From: Simon Davis
Sent: 15 April 2019 15:42
To: 'Kathryn Griffiths' [REDACTED]
Subject: FW: Y/9818/RES and Y/97/18/DOC

Comments on the revised drainage and landscape proposals:

scheme: Land off Burndell Road  
Yapton  
client: Bovis Homes  
drawing: Hard Landscape Proposals  
date: Nov. 2018  
scale: 1:200@A1  
drawing no: BOV22172 12A sheet 1  
drawn: AE checked: DKM

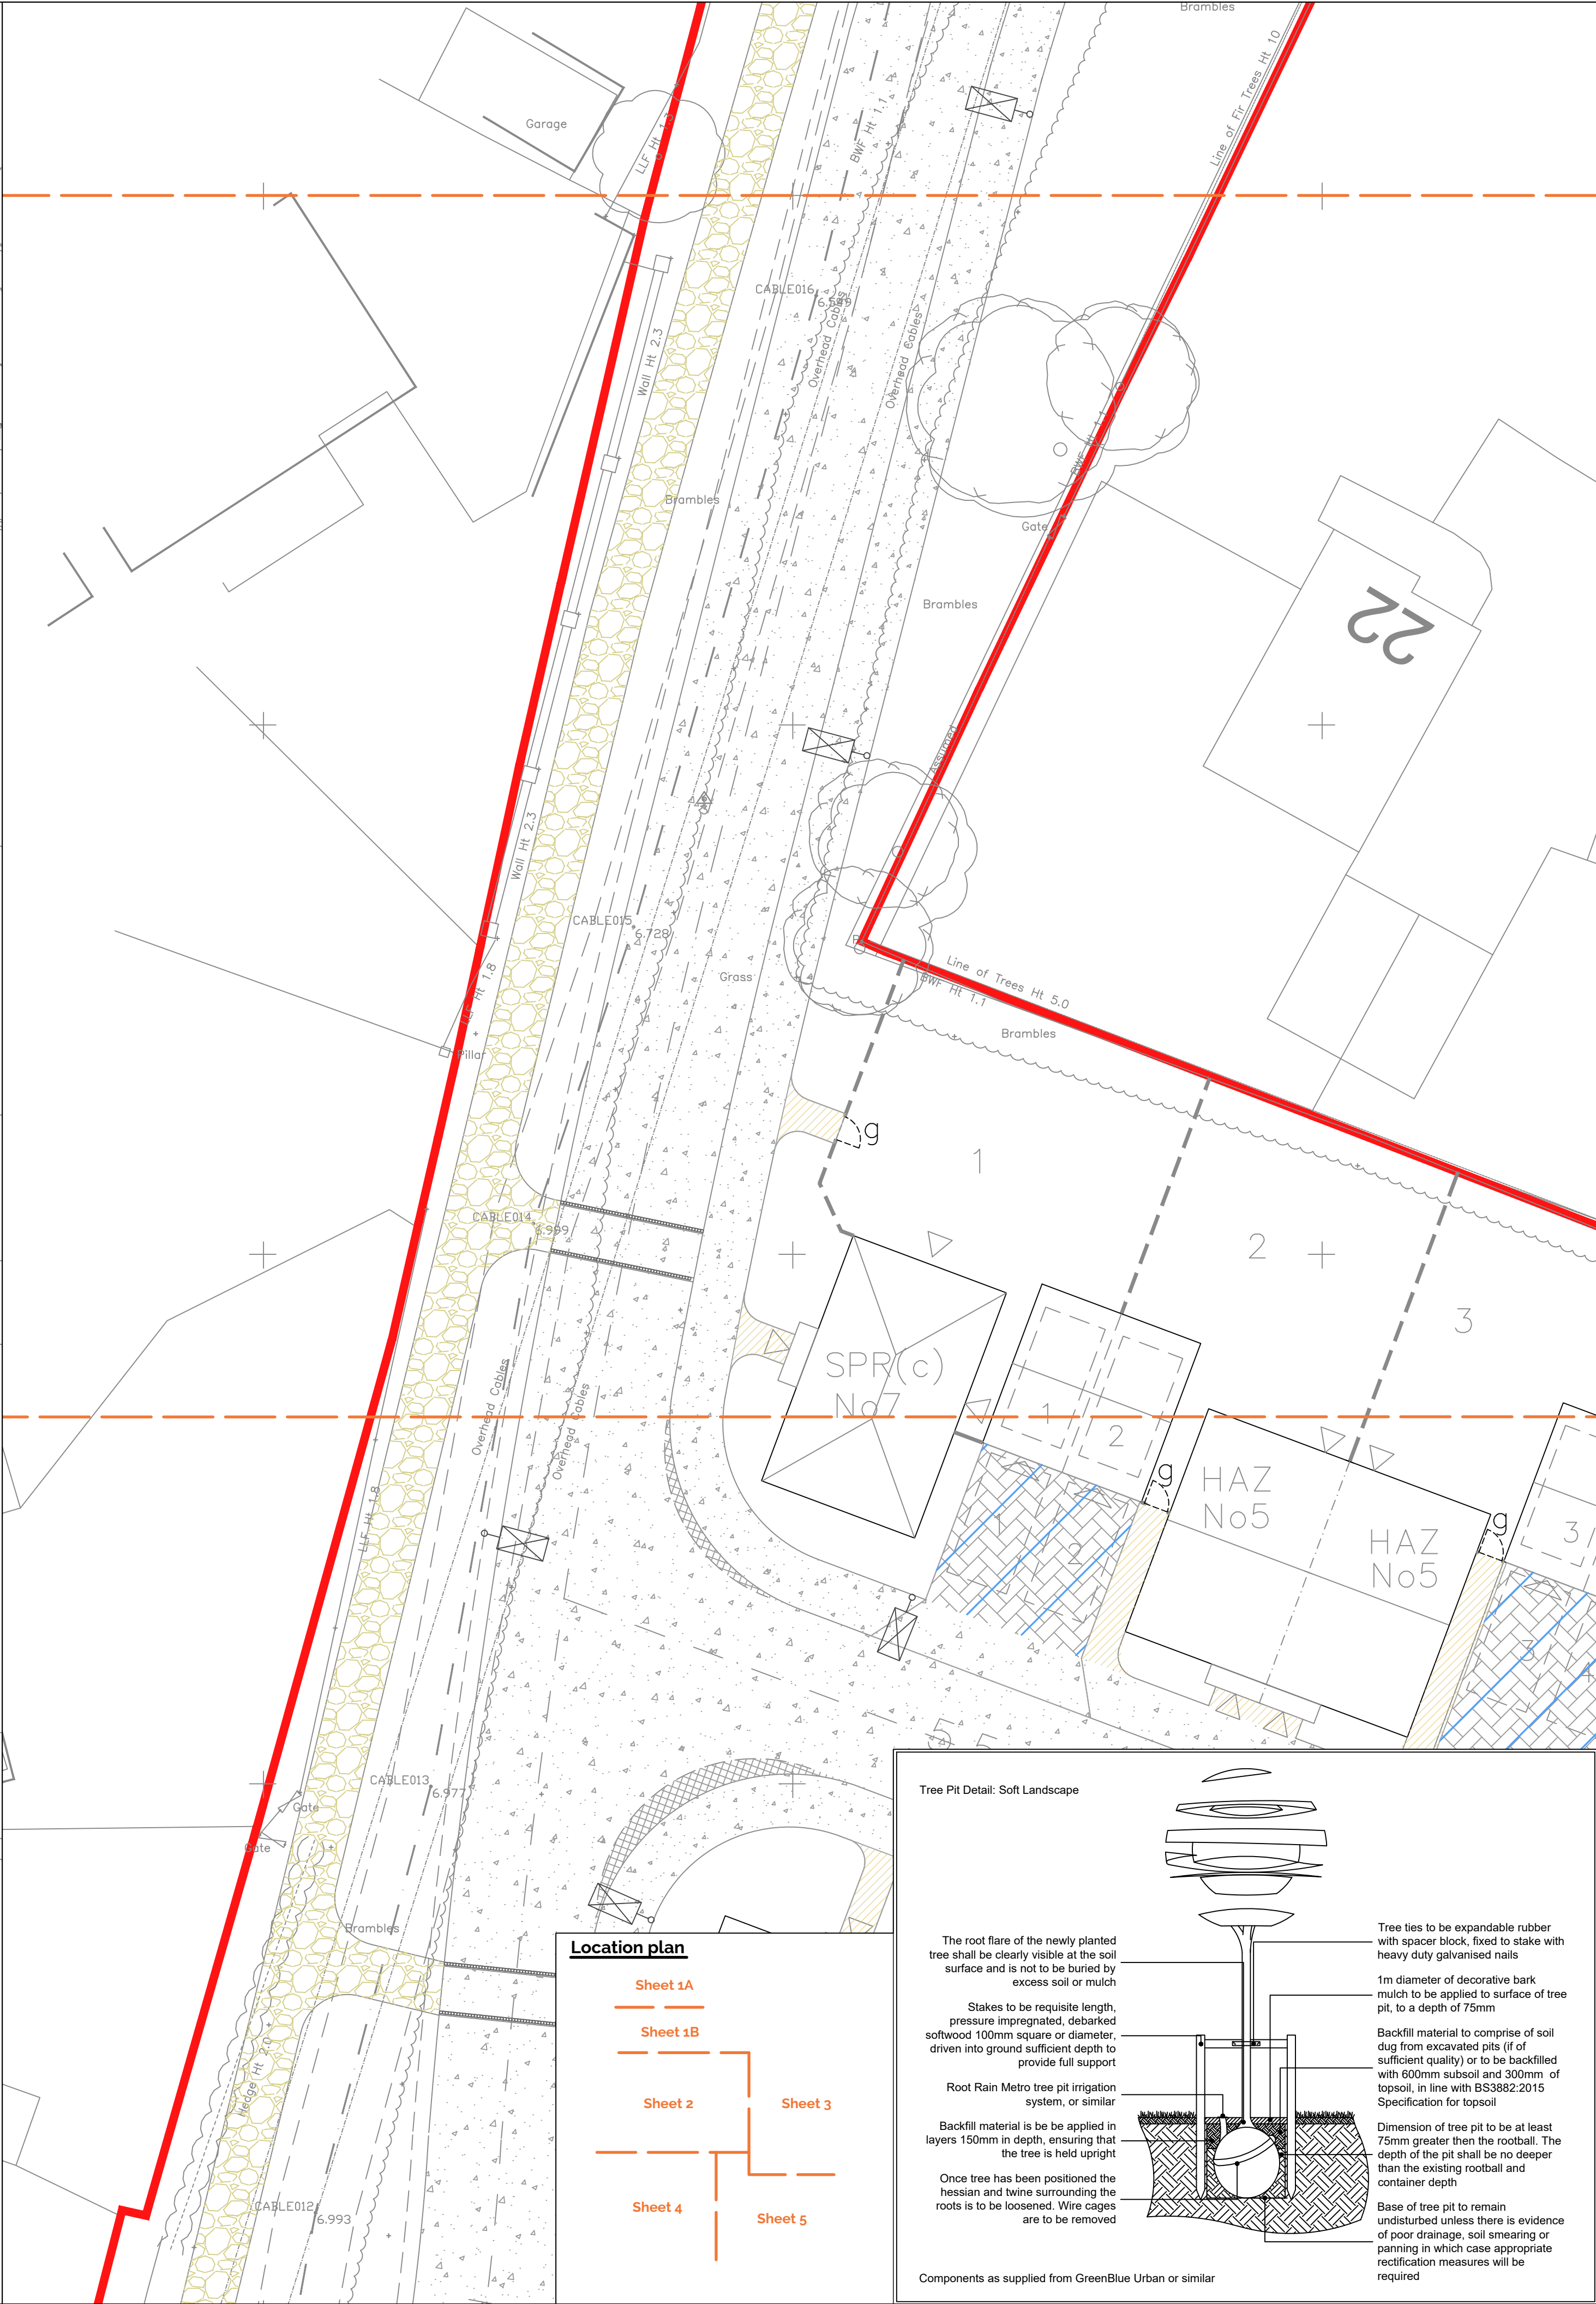
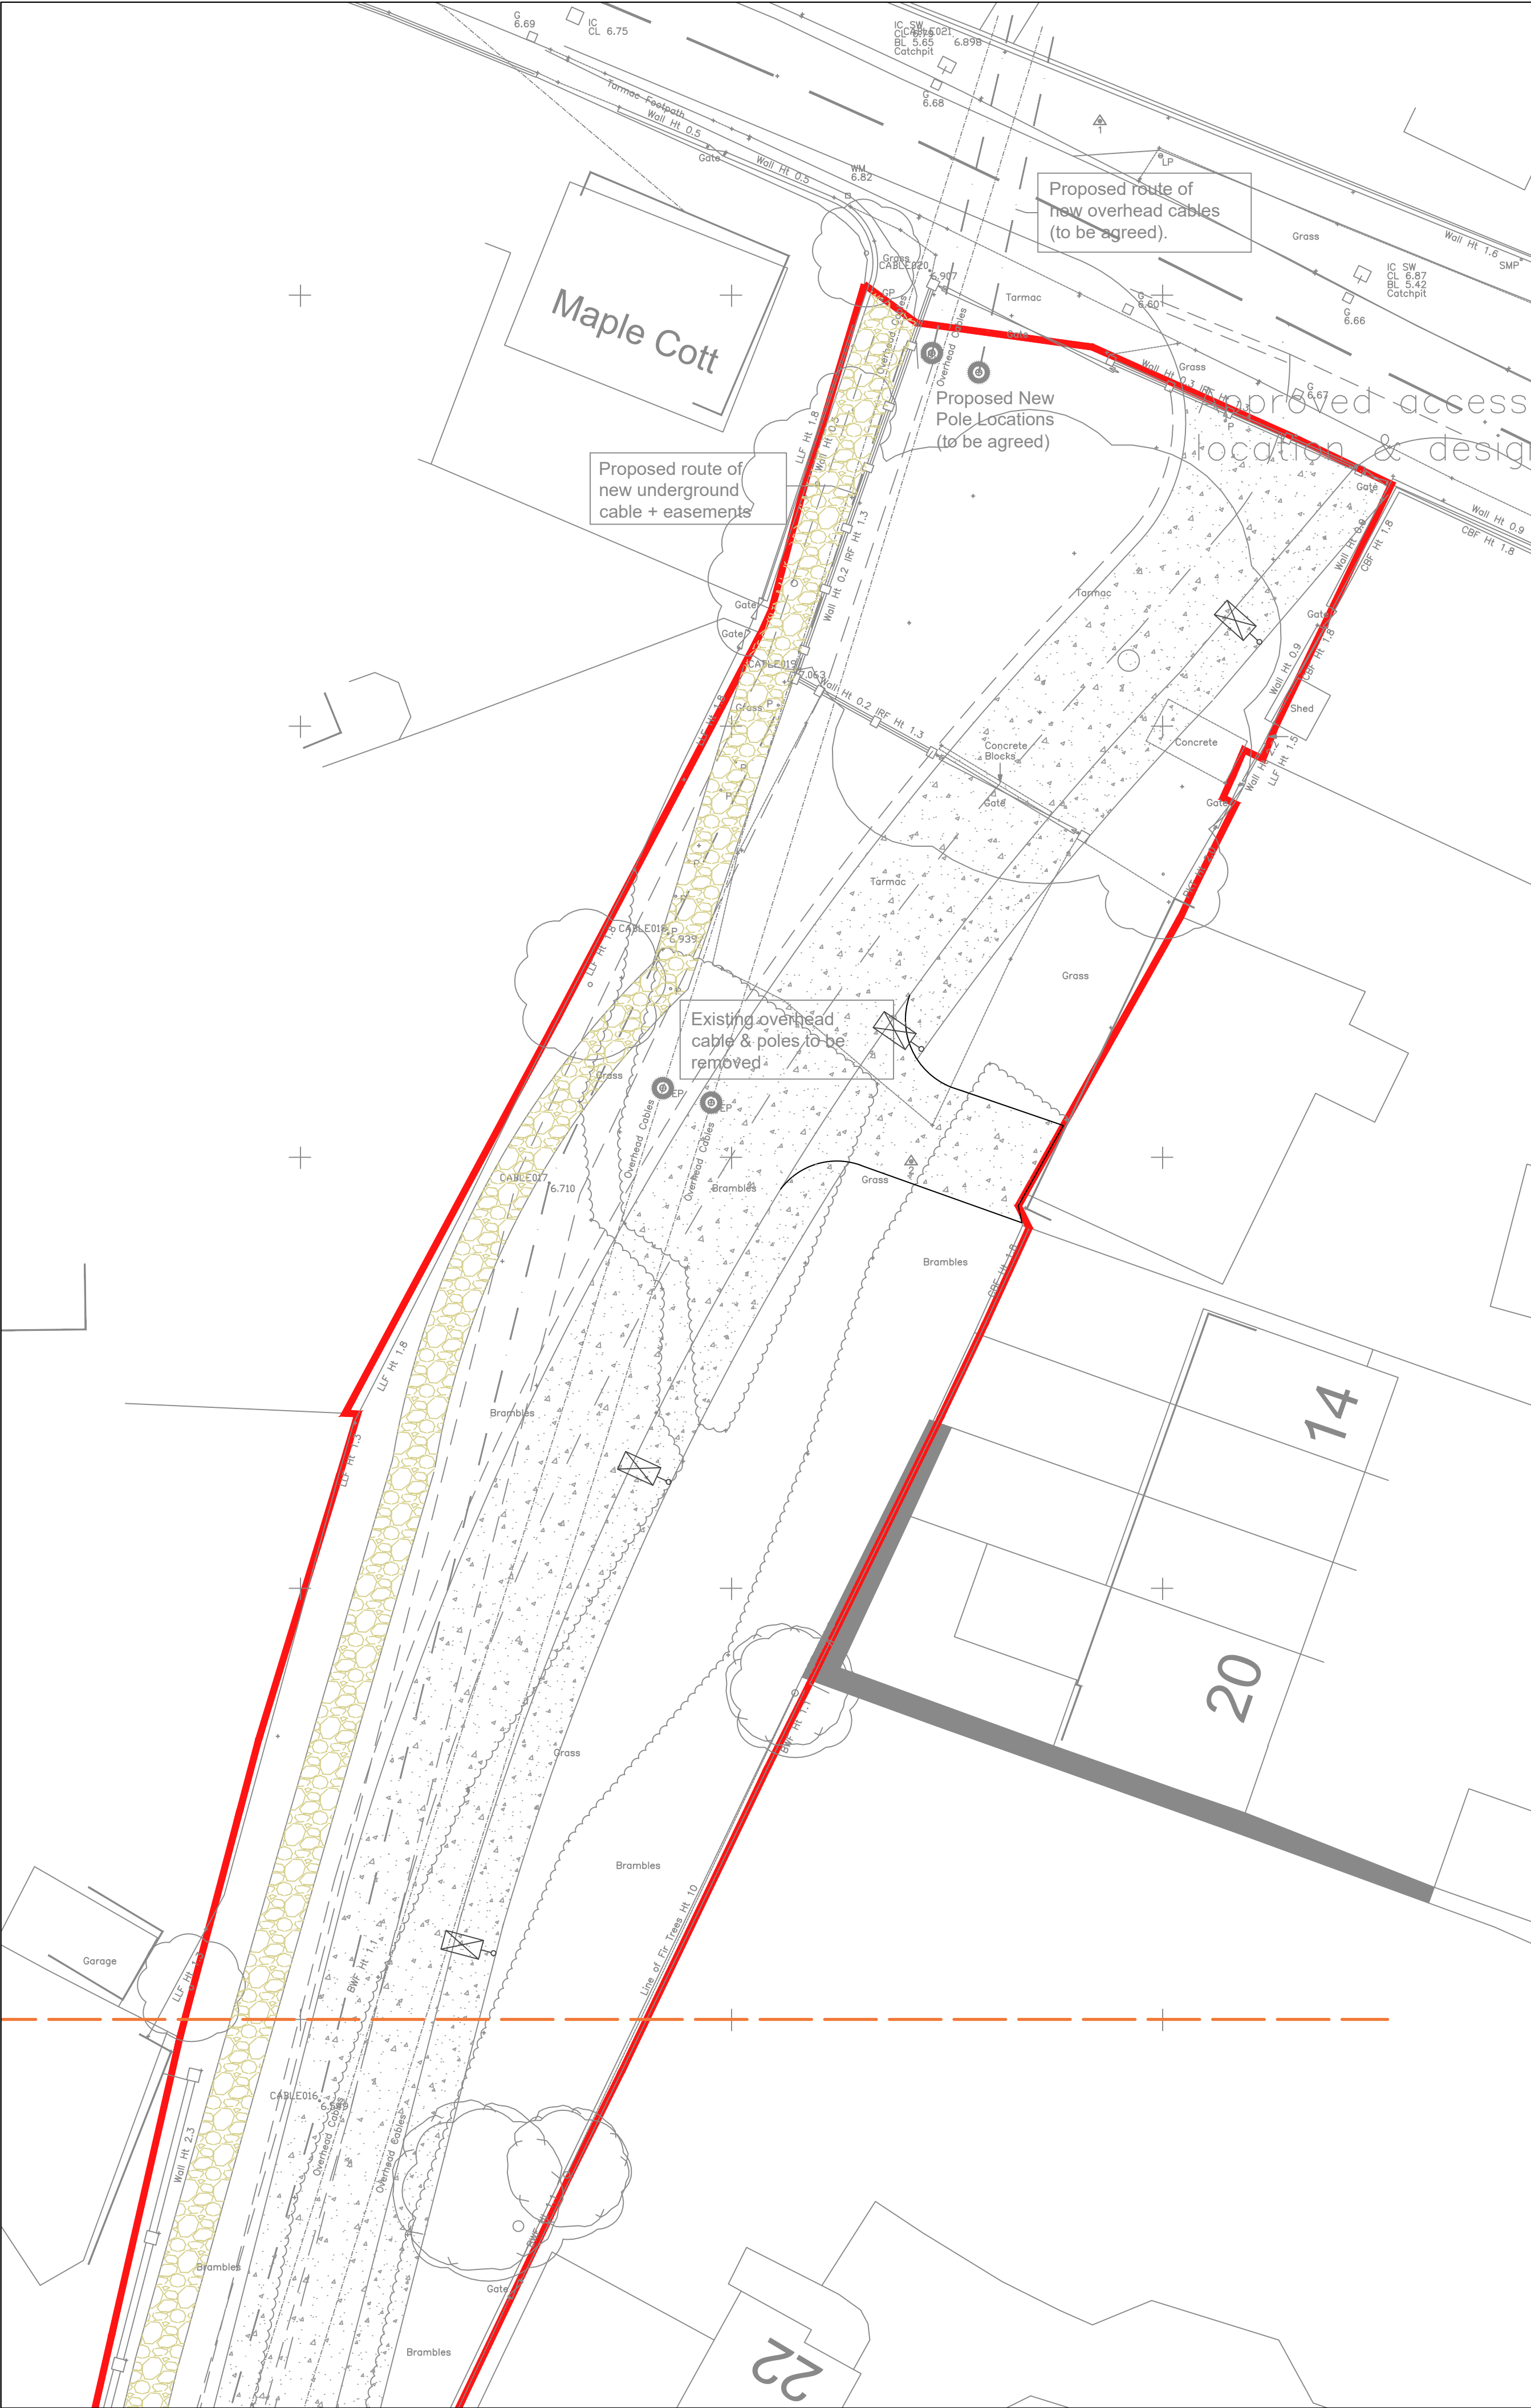
1. There are still trees proposed in close proximity to the southern-most attenuation tank.
2. A ground investigation report has been provided which details how groundwater monitoring was conducted November to December 2015. Peak ground water levels within this window were 1.64m bgl near the proposed location for the attenuation pond. Winter monitoring is required to be completed October to March inclusive. This is required even when infiltration is not proposed to ensure that the effects of flotation are adequately accounted for in design.

Scale	Date	Designed
1:500 @A1	NOV 18	SG
Drawn	Checked	Approved
SOM	LH	RS
Job No	Drawing No	Rev
18-070	18-070/103	C

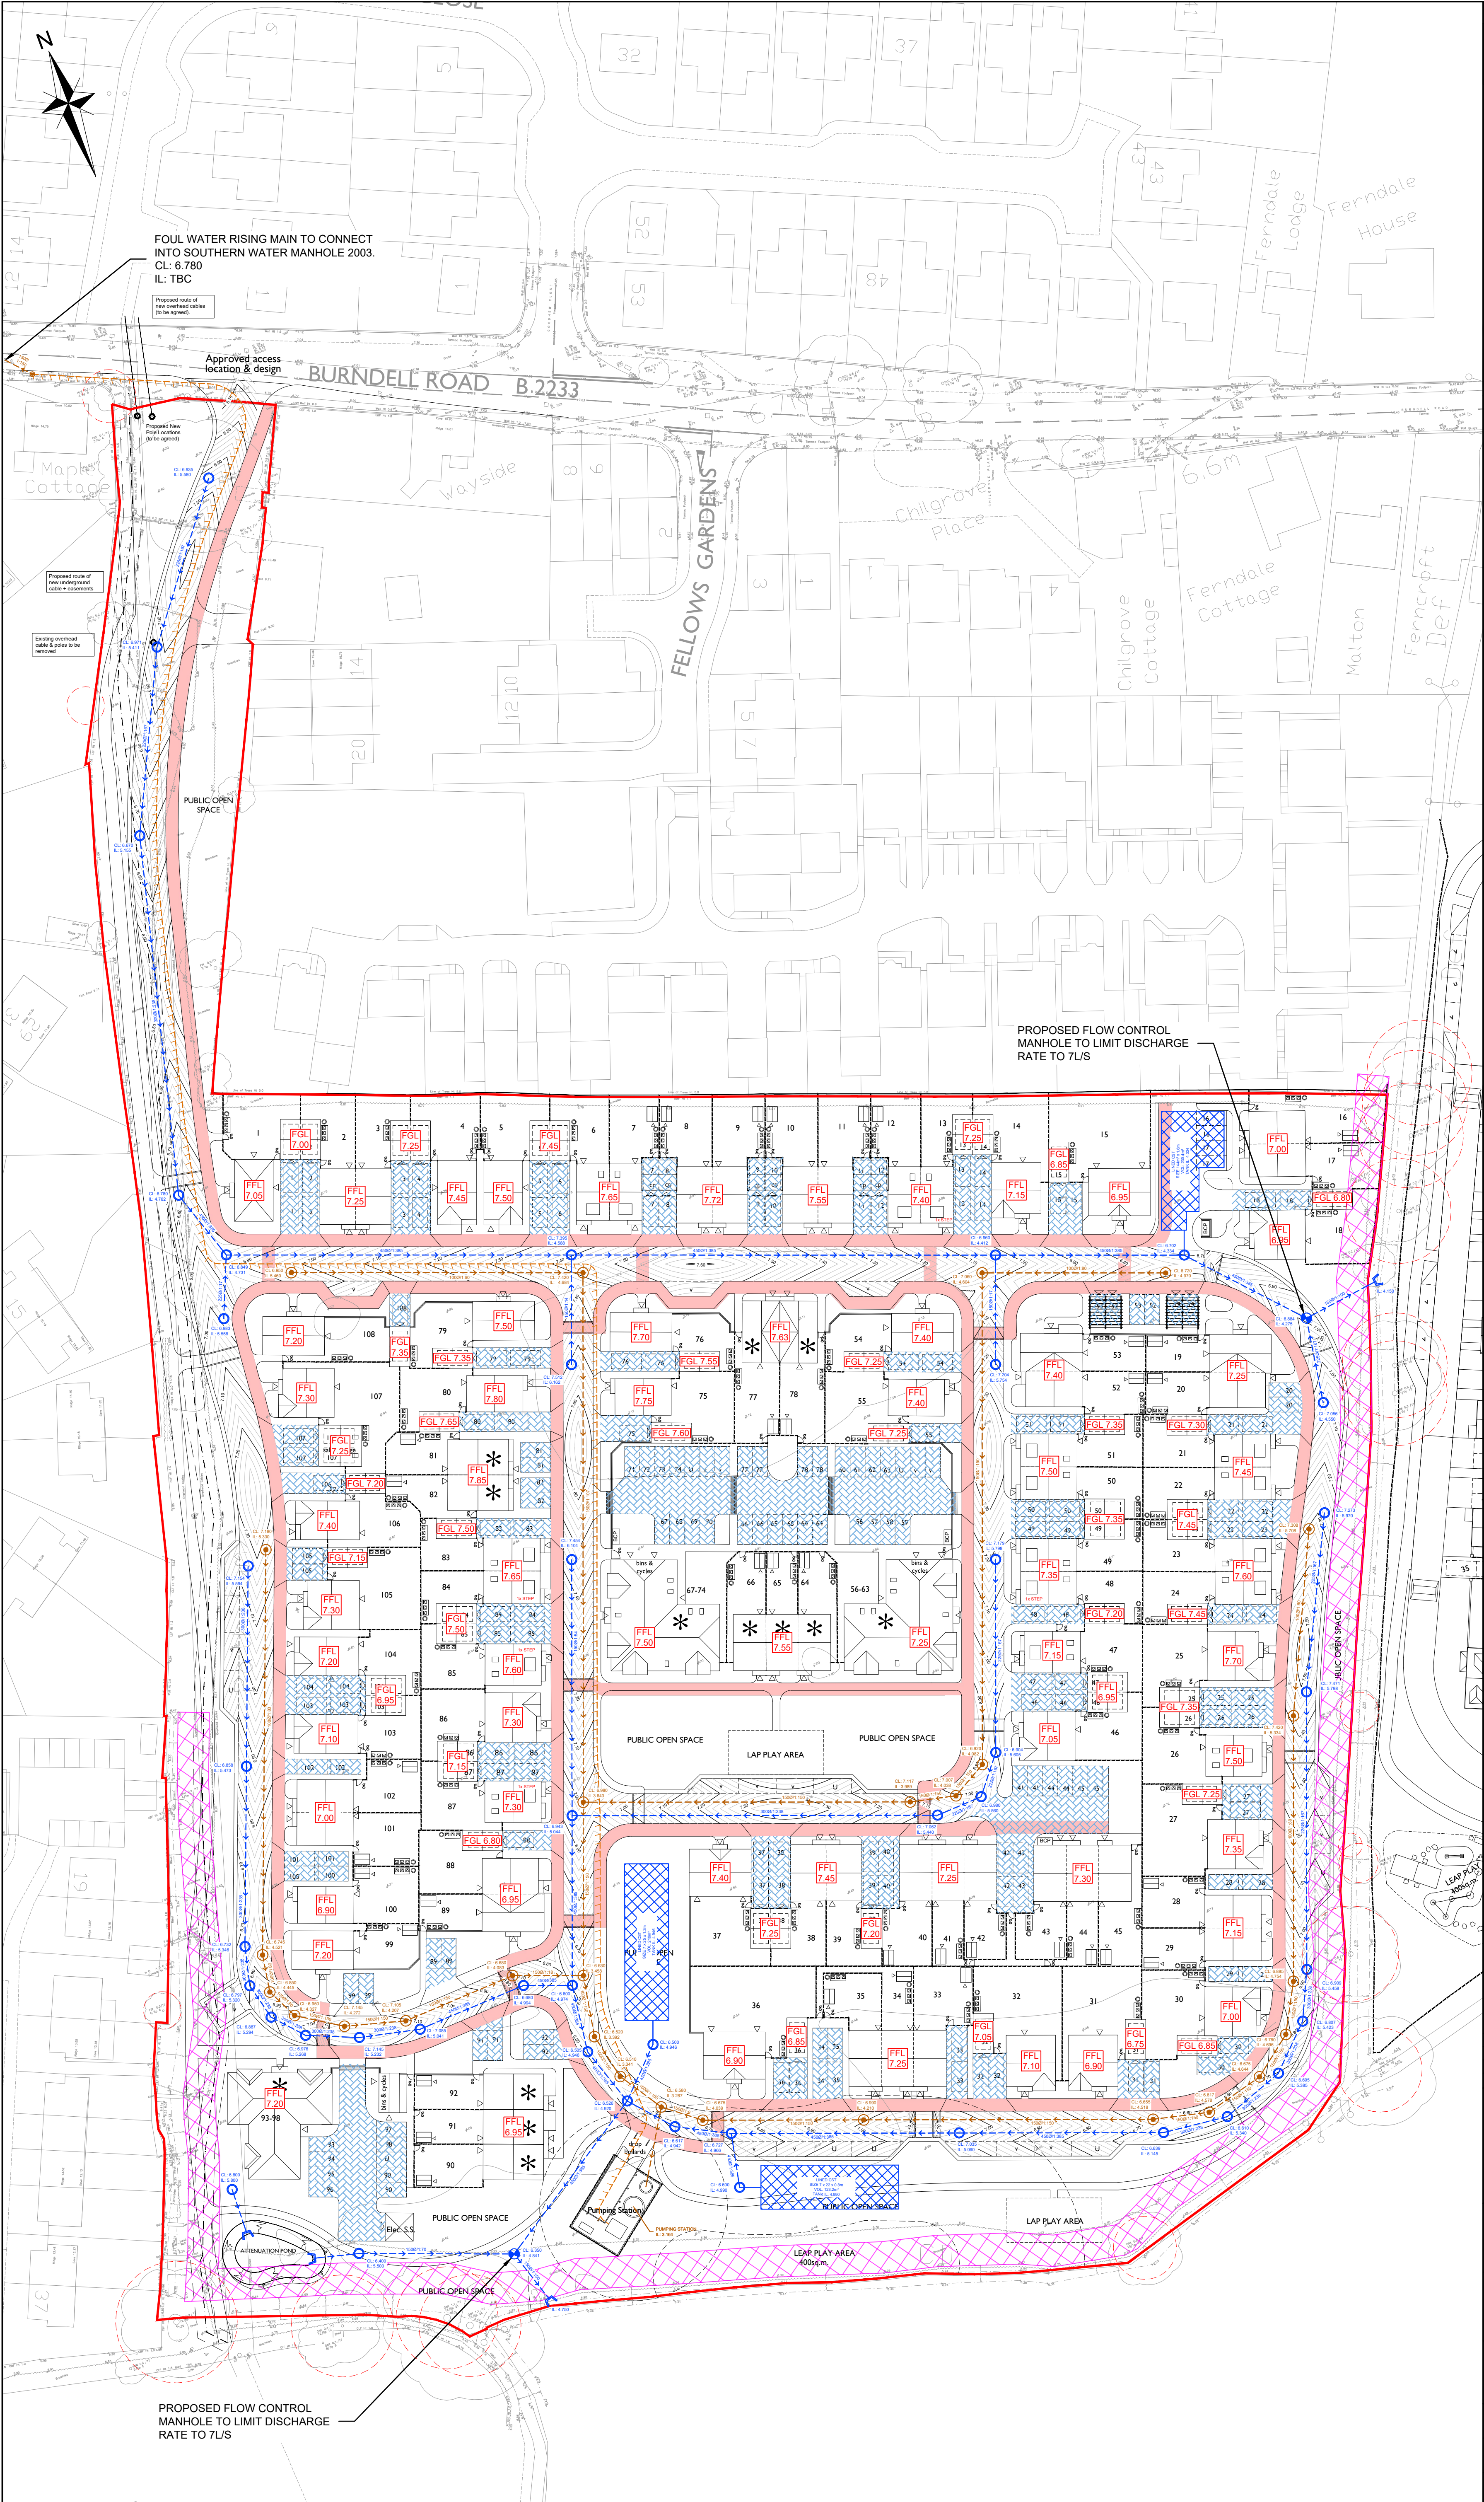
4. Top of bank levels, invert levels and slope need to be labelled on proposed ponds.
5. Proposed invert levels of outfalls to ditches appear to be low in comparison to surrounding bed levels. A minimum of 150mm must be provided between the invert level of outfall and ditch bed level.

6. Details of how the permeable paving links to the main drainage system have not been provided.
